RE: Existing Septic System Inspection HTE# 09-5-22570
Applicant: Rising Sun pools – Kintwood Estates Lt. A

An attempt was made to evaluate your property for the purpose of issuing an Existing Tank Permit. The evaluation could not be completed for one or more of the following reasons.

09 500 22570  
 SITE PLAN APPROVAL  
 DISTRICT RA30 USE POOL  
 #BEDROOMS N/A  
 7/31/09 [Signature]  
 Veronica [Signature]

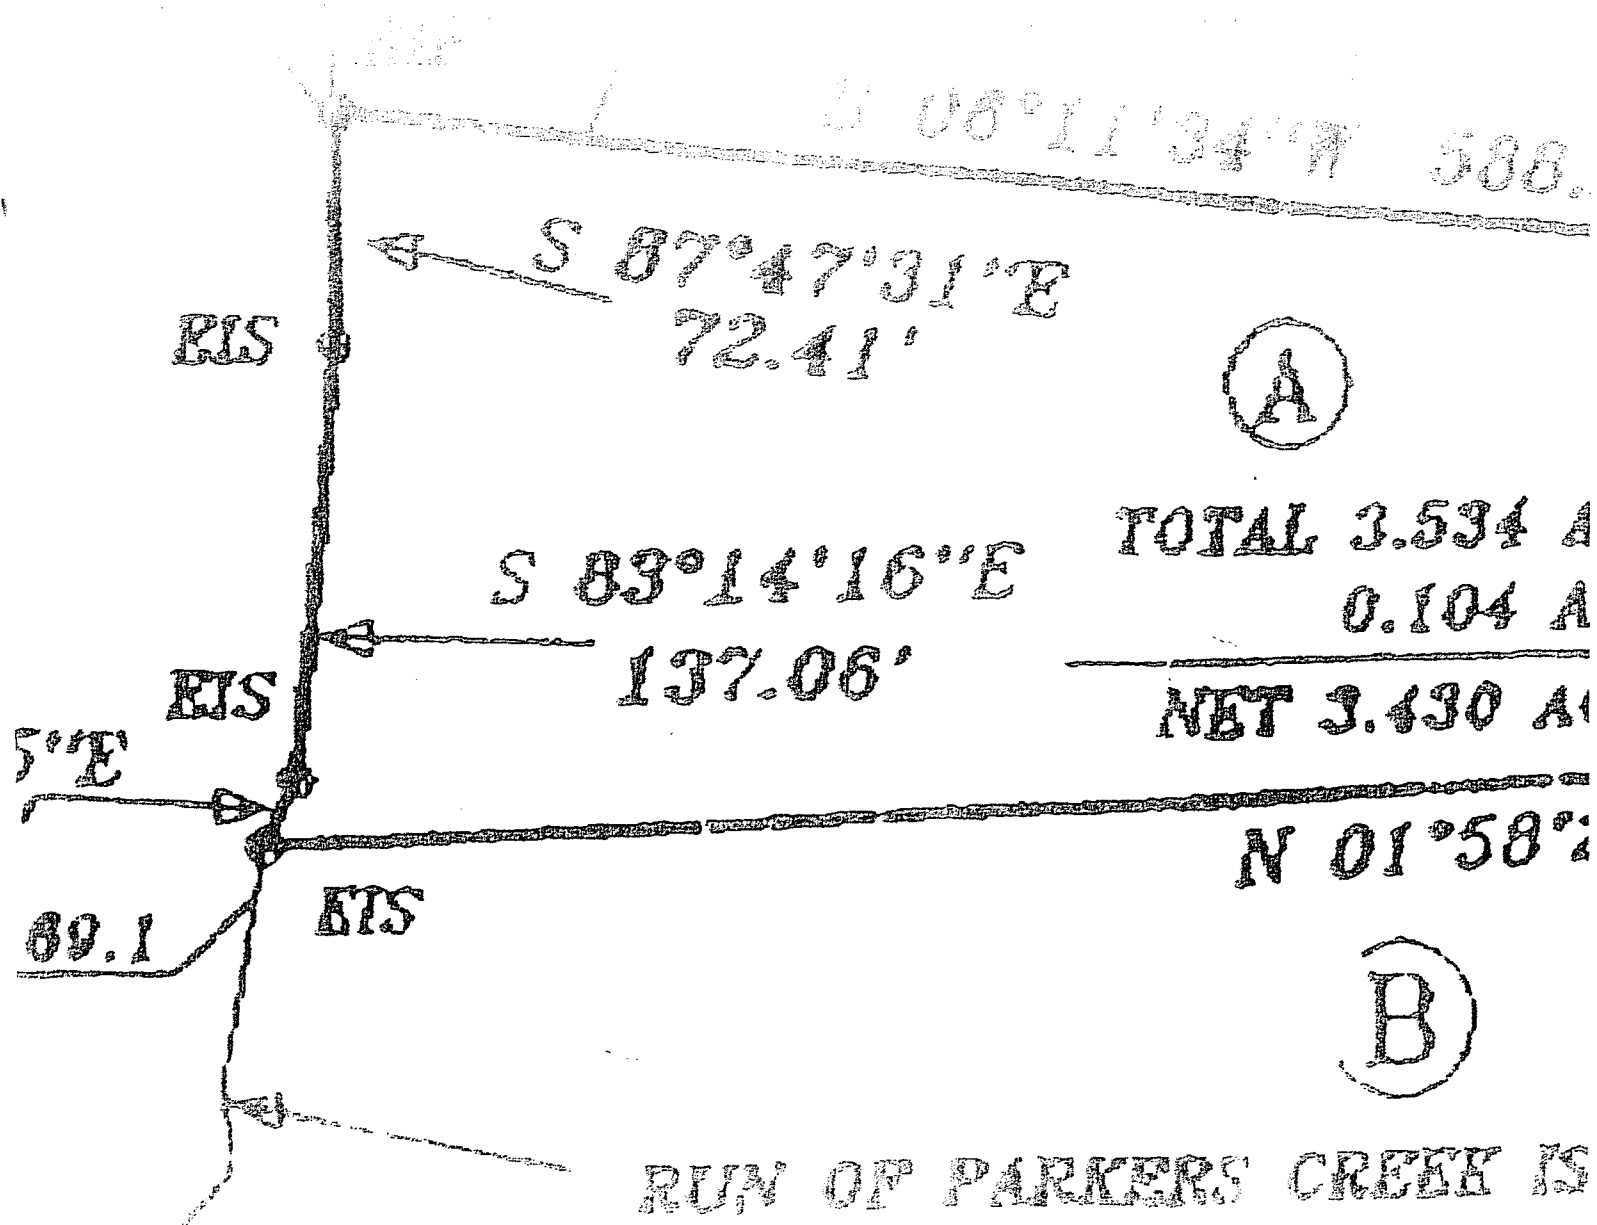
4. Other – In addition to uncovering the outlet lid you need to locate and uncover the distribution box. Also, mark your existing drain field to demonstrate 15 feet from proposed in ground pool.
